Development Control
Ribble Valley Borough Council

App no: 24.0898

Address: Field to the south of Clitheroe Road and east of Cow Ark Brook, Cow Ark

Proposal: Engineering works to create four wetland ponds, ditches and banked hedges.

Cow Ark Wetland Location

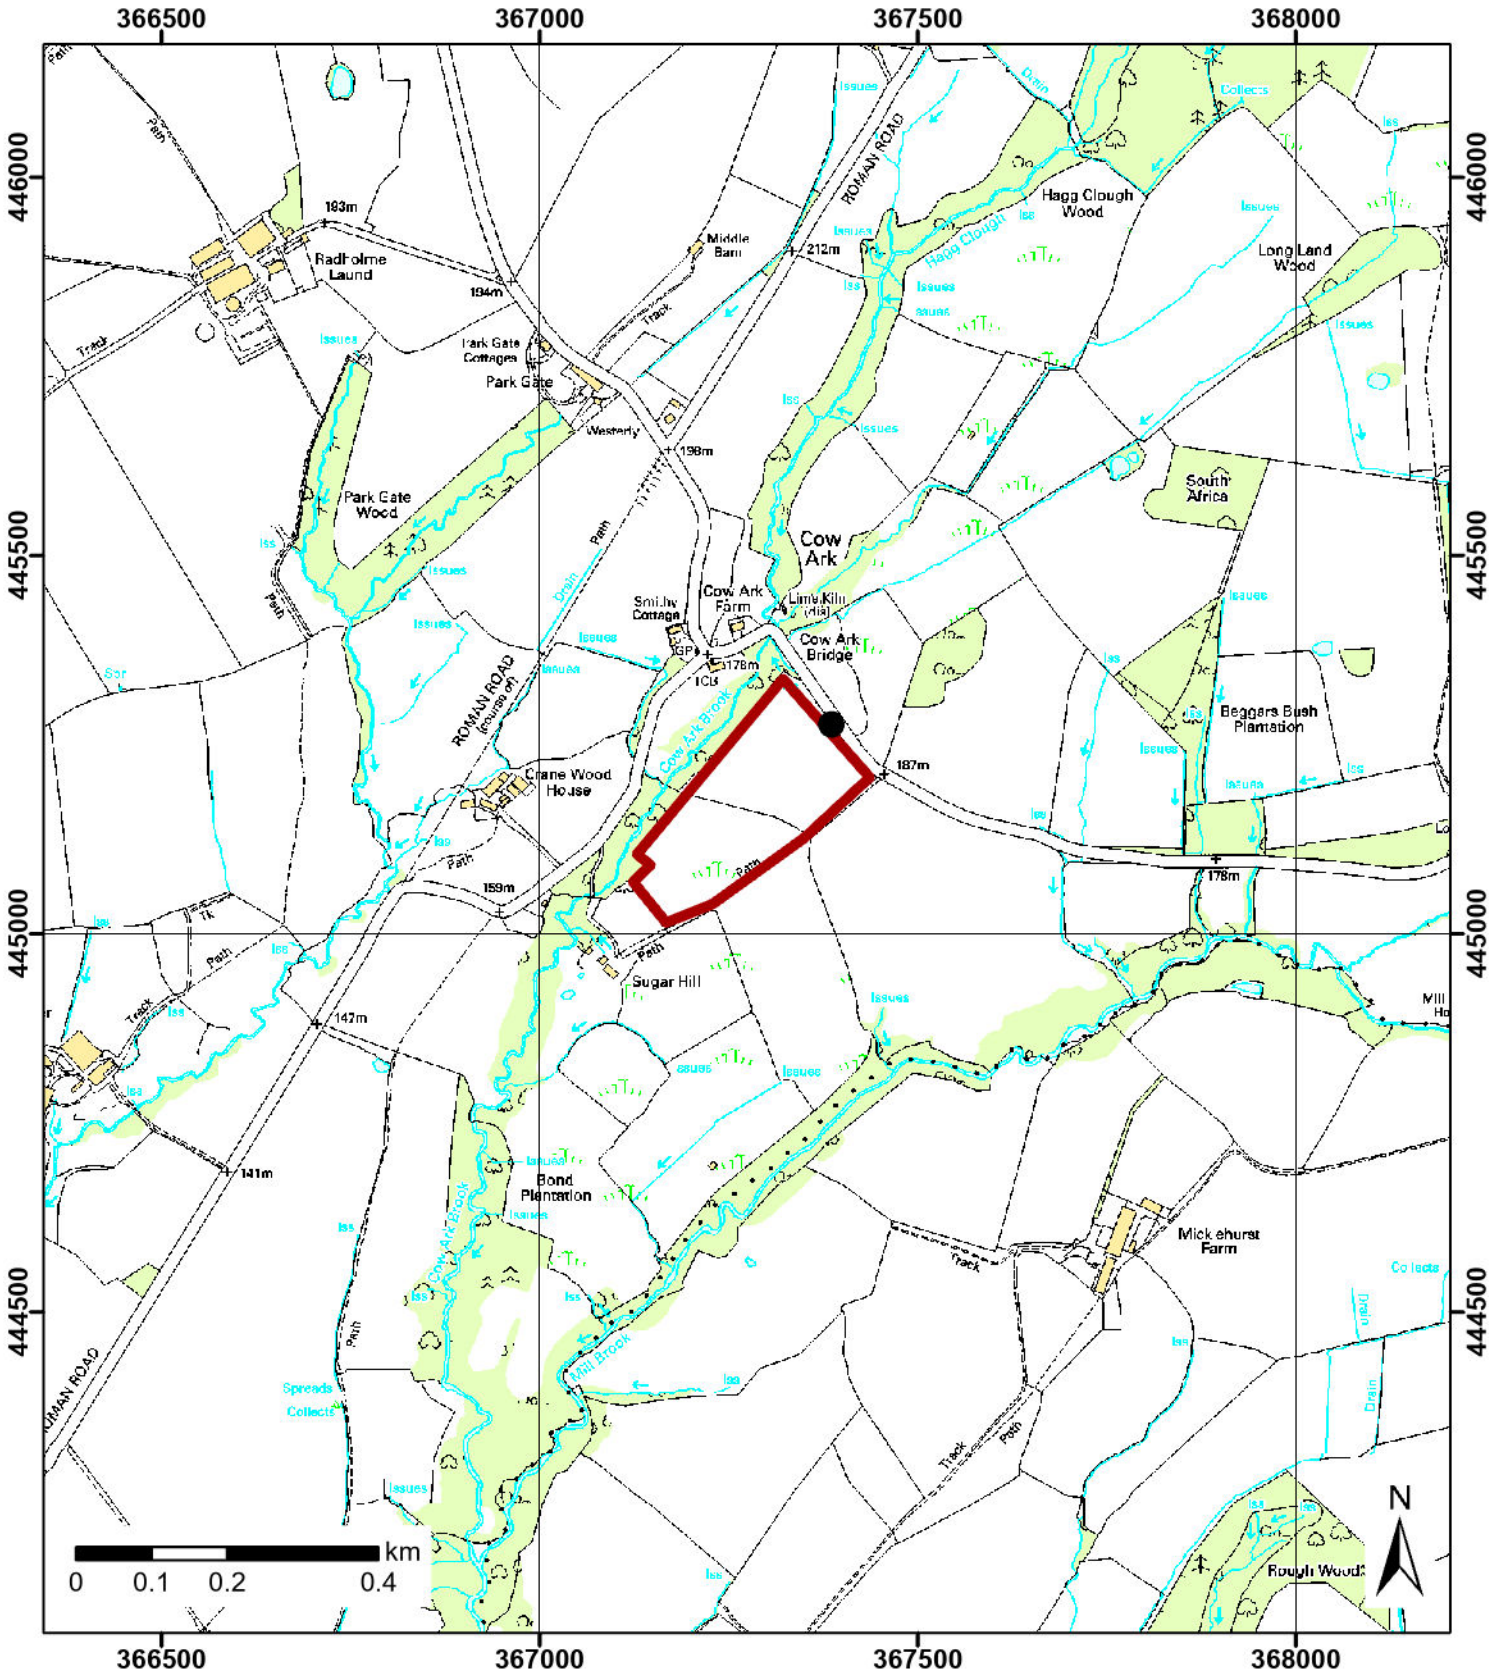
A photograph is submitted of an existing field gate on Clitheroe Road at grid reference 367373, 445305, approximately 110m southeast of Cow Ark Bridge. There is currently no hardstanding within the field.

A compound will be created, there are no details of the location, size or surface material.

The small number of vehicle movements over a temporary period appears acceptable however the compound should be sufficient in size to allow all vehicles to turn and exit onto Clitheroe Road in forward gear and laid with a stone surface. All wheels should be washed before vehicles re-enter Clitheroe Road to prevent mud being deposited onto the highway for highway safety.

We would request that the boundary hedges on the Clitheroe Road boundary are kept below 1m high for the period of the project should it occur during the summer months to maximise the visibility splays for vehicles emerging at the access for highway safety.

1. For the full period of construction facilities shall be available on site for the cleaning of the wheels of vehicles leaving the site and such equipment shall be used as necessary to prevent mud, stones and debris being carried onto the highway. Provision to sweep the surrounding highway network by mechanical means will be available and the roads adjacent to the site shall be mechanically swept as required during the full construction period.
Reason: To prevent stones, mud and debris being carried onto the public highway to the detriment of road safety

2. The layout of the development shall include provisions to enable vehicles to enter and leave the highway in forward gear and the vehicular turning space shall be laid out and be available for use before the development is brought into use.
Reason: Vehicles reversing to and from the highway are a hazard to other road users.

3. The boundary hedges along Clitheroe Road shall be kept below 1m for the temporary period during the development project hereby permitted. Reason For highway safety to maximise visibility splays for emerging vehicles and highway users.
